Item No. **Report of the Head of Planning, Sport and Green Spaces**

Address 27 CHARVILLE LANE WEST HILLINGDON

Development: Single storey rear/side extension to include 1 x rear roof lantern and porch to front

LBH Ref Nos: **15206/APP/2014/140**

Scale 1:50
No: 205
Date 5th January 2014

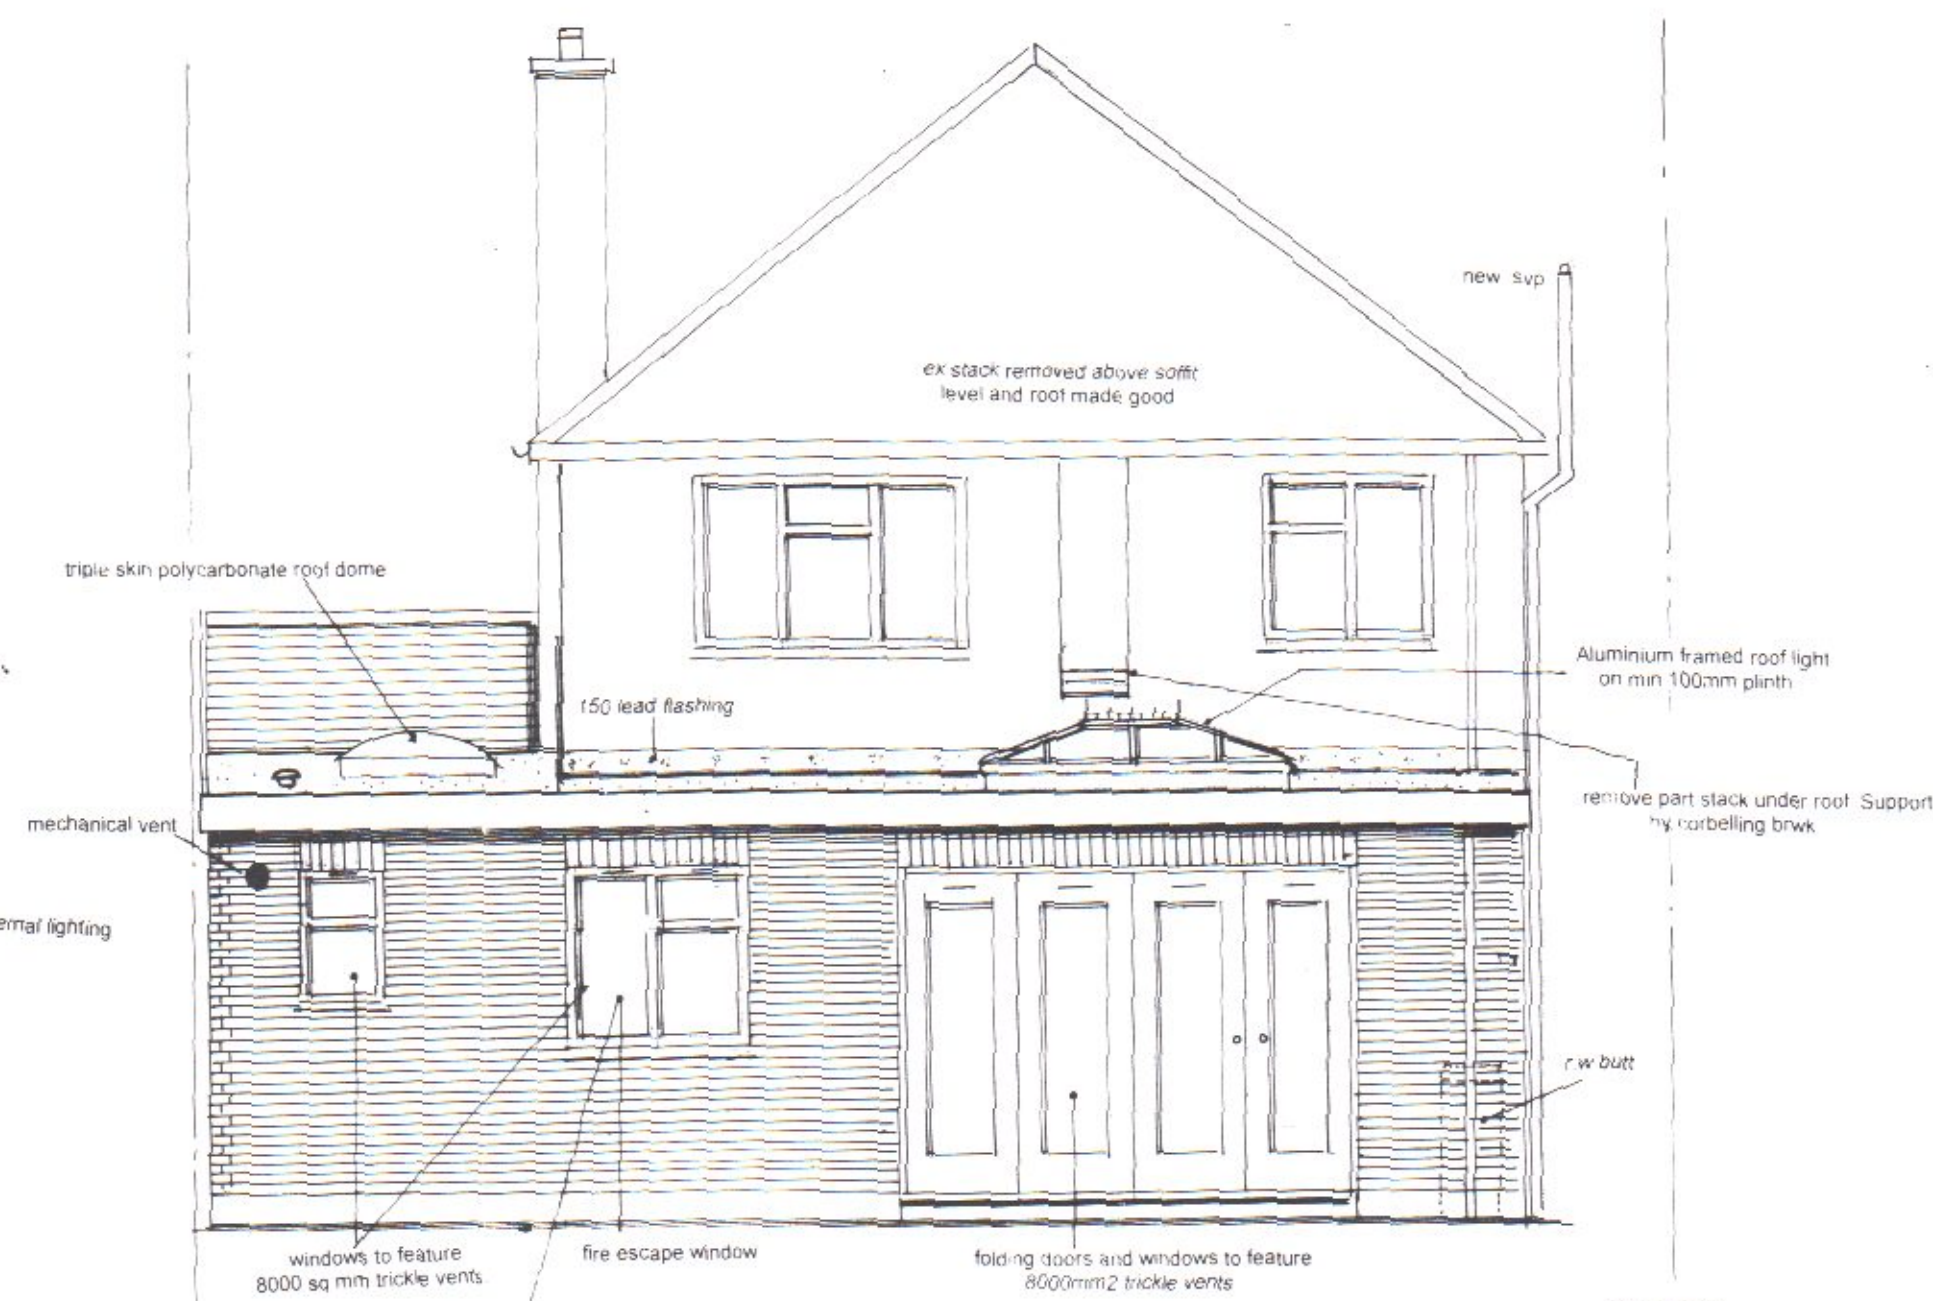
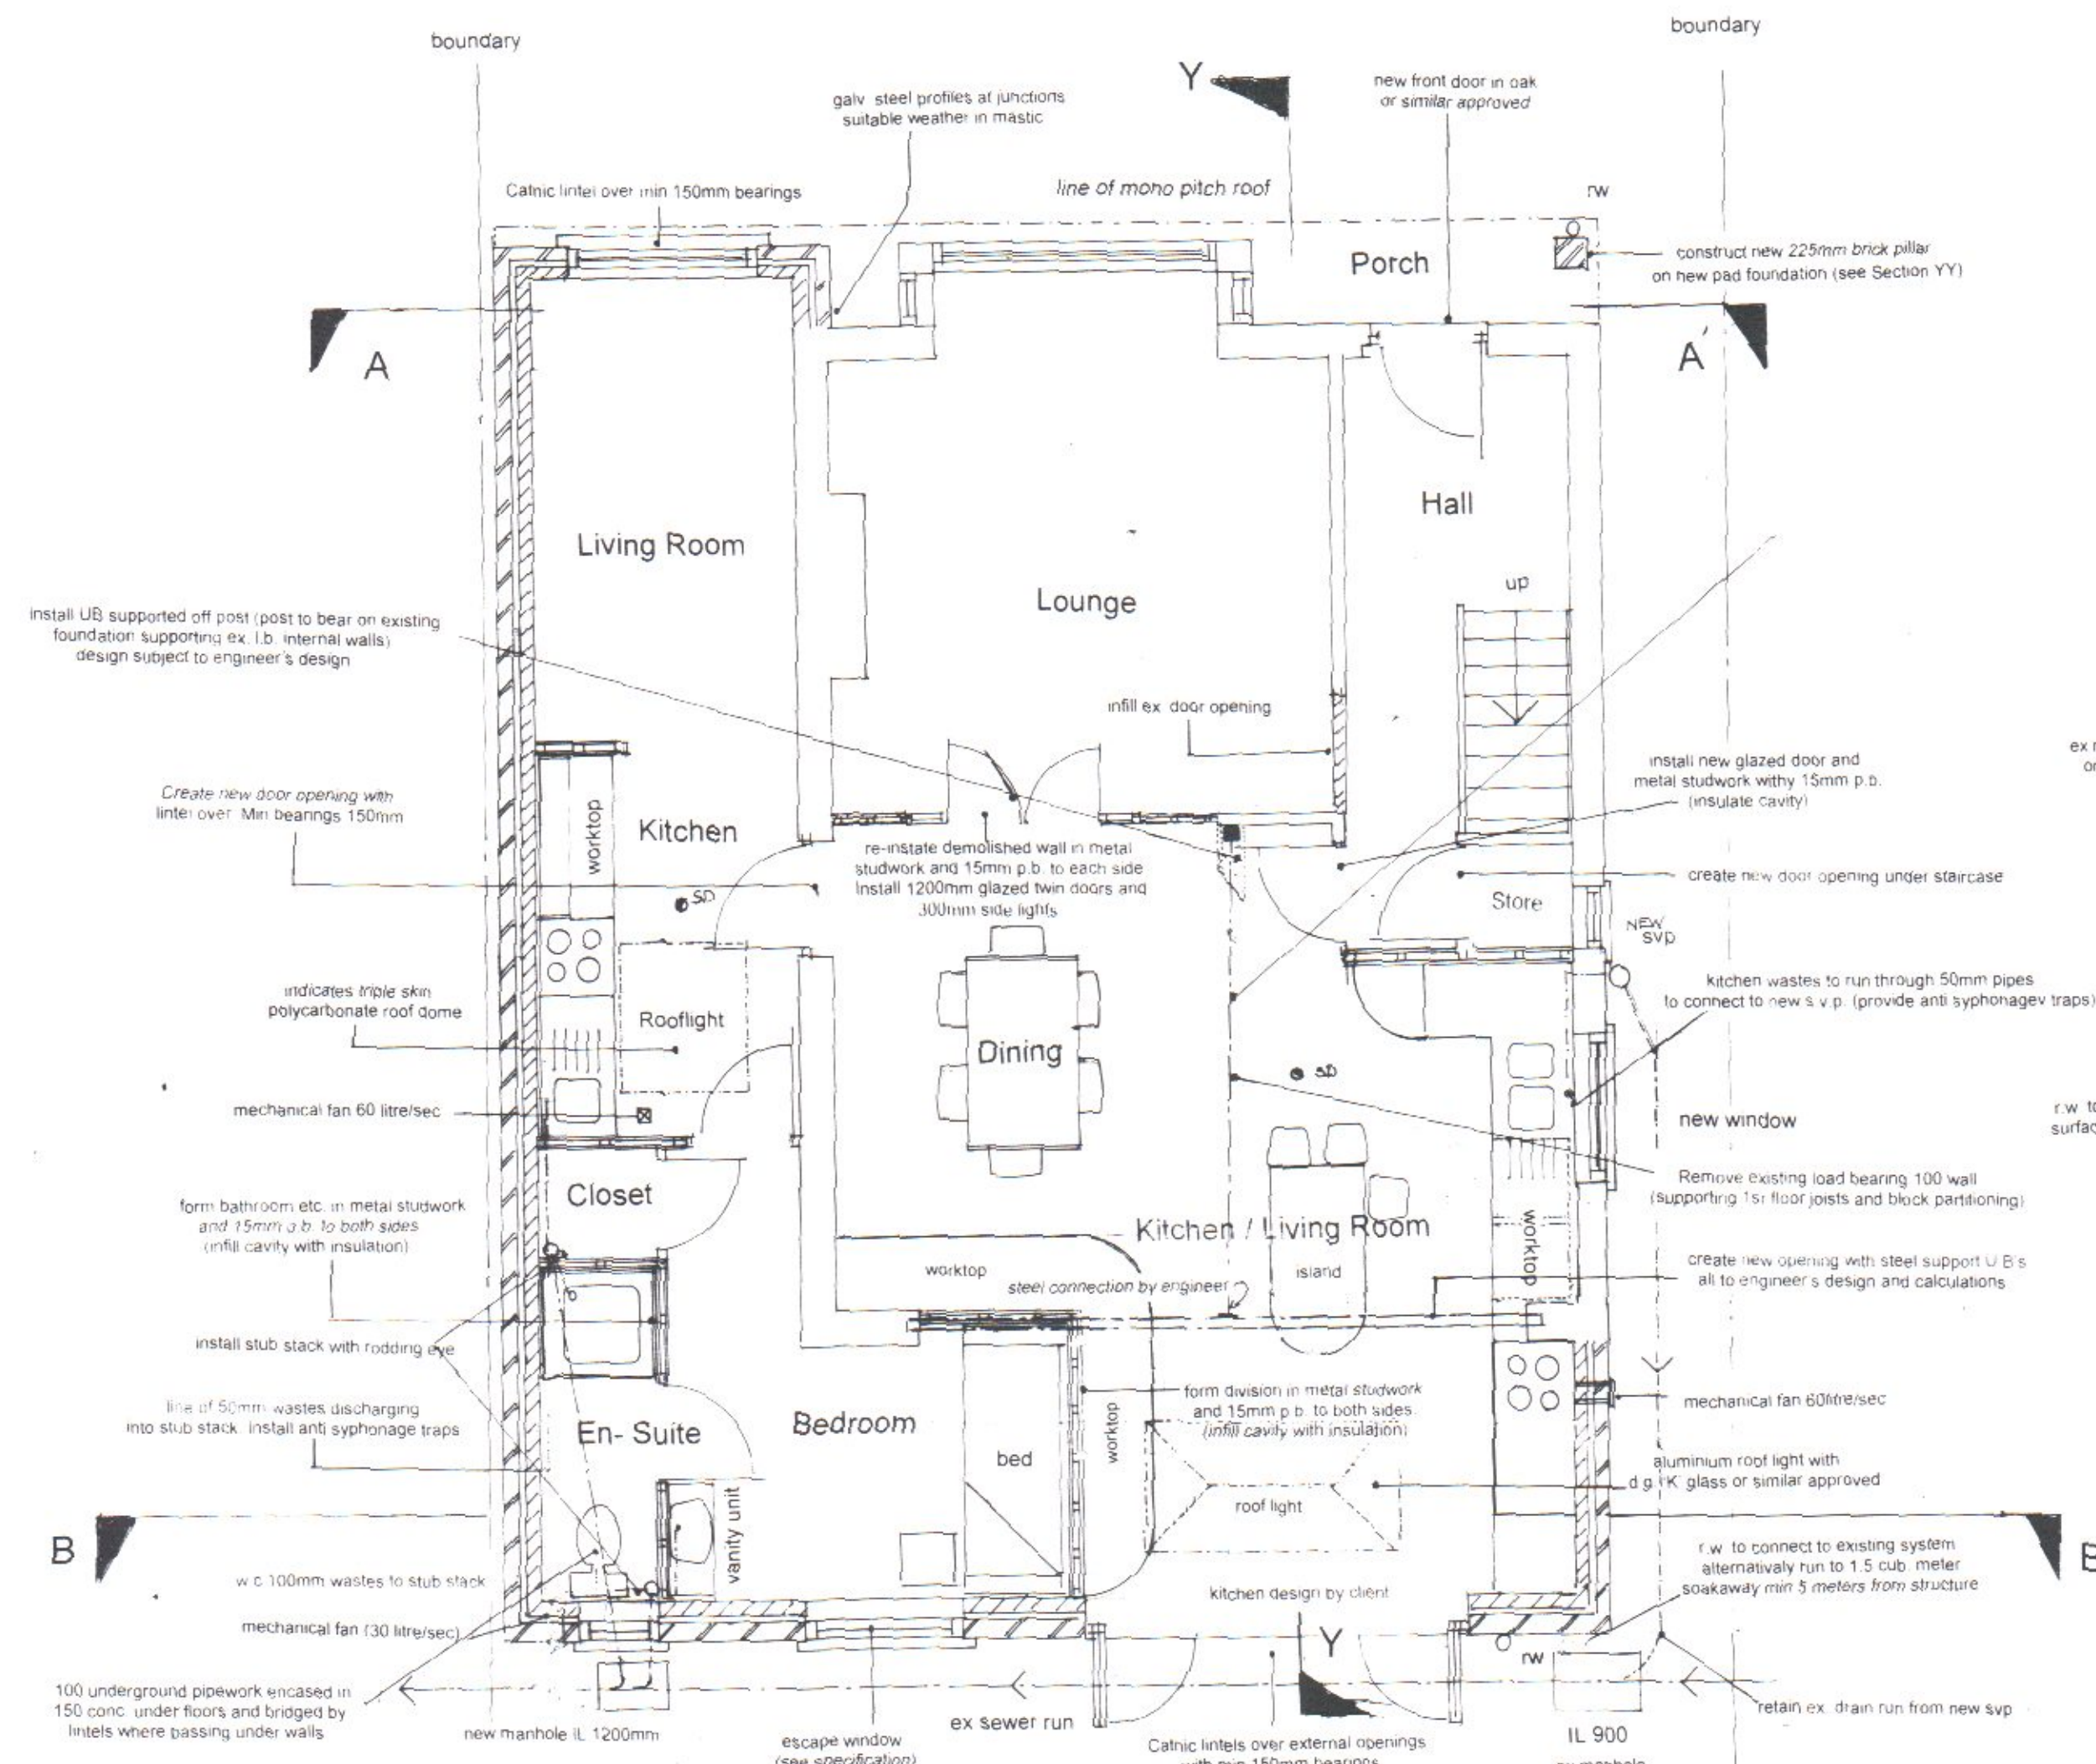
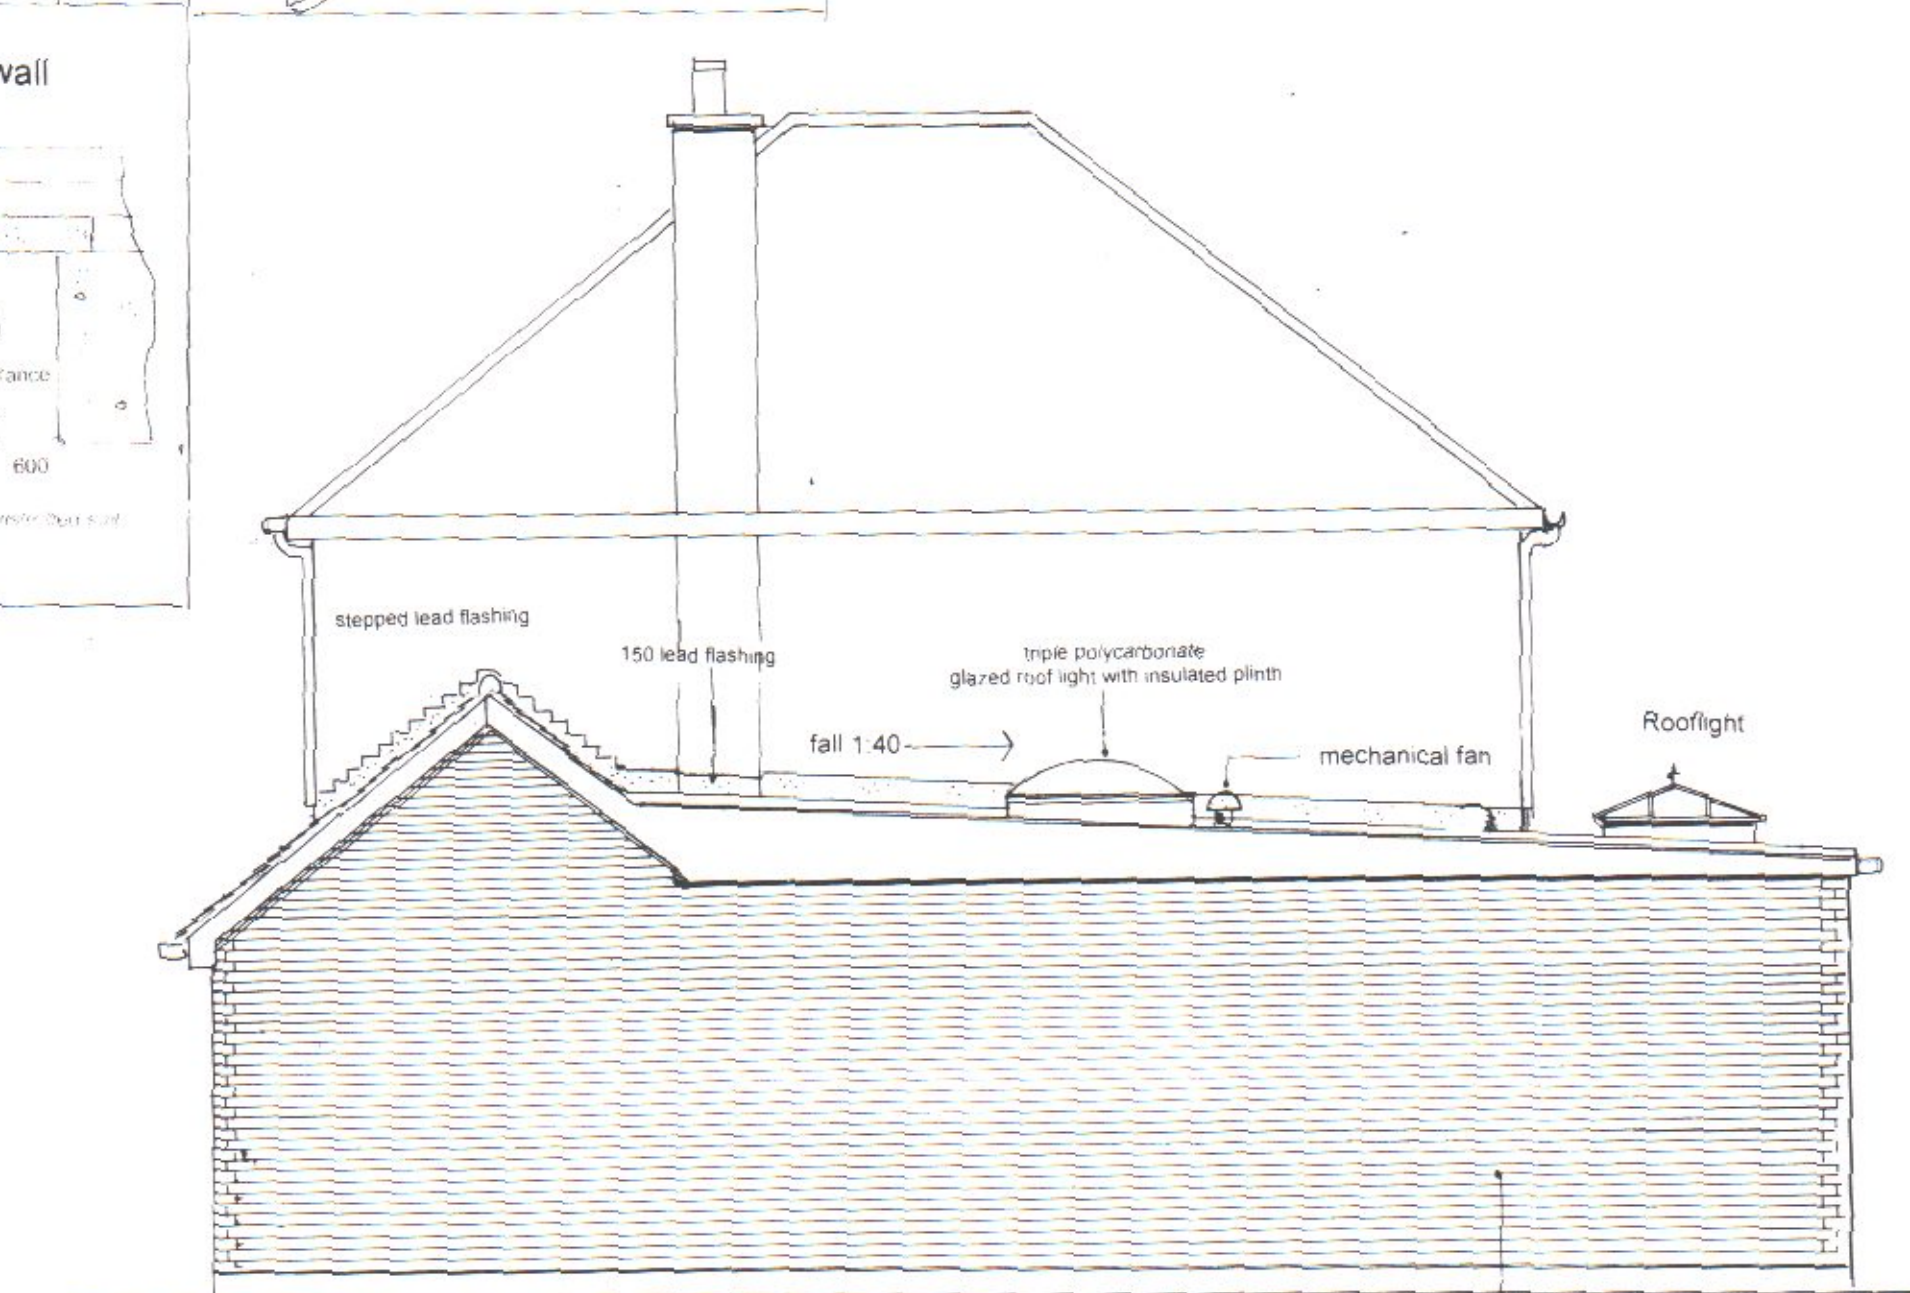
The side element replaces an existing garage. Whilst the height of the side extension would exceed the 3.4m height advised within the HDAS Guidance, it is considered that this would be acceptable, given the character and height of the catslide roofs above many garages within the immediate locality. However, concerns are raised in respect of the proposed front porch/canopy which extends from the proposed side extension across the entire width of the host dwelling. Paragraph 8.1 of the HDAS guidance states that The Council is very explicit with regard to its position on front extensions. Front extensions that extend across the entire frontage will normally be refused. Front extensions are eye catching and change the face of the building.

They do not only affect the character and appearance of the building itself, but also the street scene. There are no other examples of extensions across the entire frontage of the properties within the immediate locality and it is considered that the proposal would result in an incongruous addition to this property which would detract from its character and appearance within the street scene, given the uniformity between buildings on this side of the street. As such the proposal is considered unacceptable in respect of Policy BE1 of the Hillingdon Local Plan: Part One - Strategic Policies (November 2012), policies BE13 and BE15 of the Hillingdon Local Plan: Part Two - Saved UDP Policies (November 2012) and the advice contained within the HDAS Guidance "Residential extensions".

Having regard to the scale, bulk and design of the proposed front porch/canopy across the entire width of the host dwelling the proposal would result in an incongruous addition which would be detrimental to the architectural composition of the existing building, the street scene, and would harm the character and appearance of the wider area. The proposal would therefore be contrary to Policy BE1 of the Hillingdon Local Plan: Part One - Strategic Policies (November 2012), Policies BE13, BE15 and BE19 of the Hillingdon Local Plan - Saved UDP Policies (November 2012) and to the Council's Supplementary Planning Documents HDAS Residential Extensions.
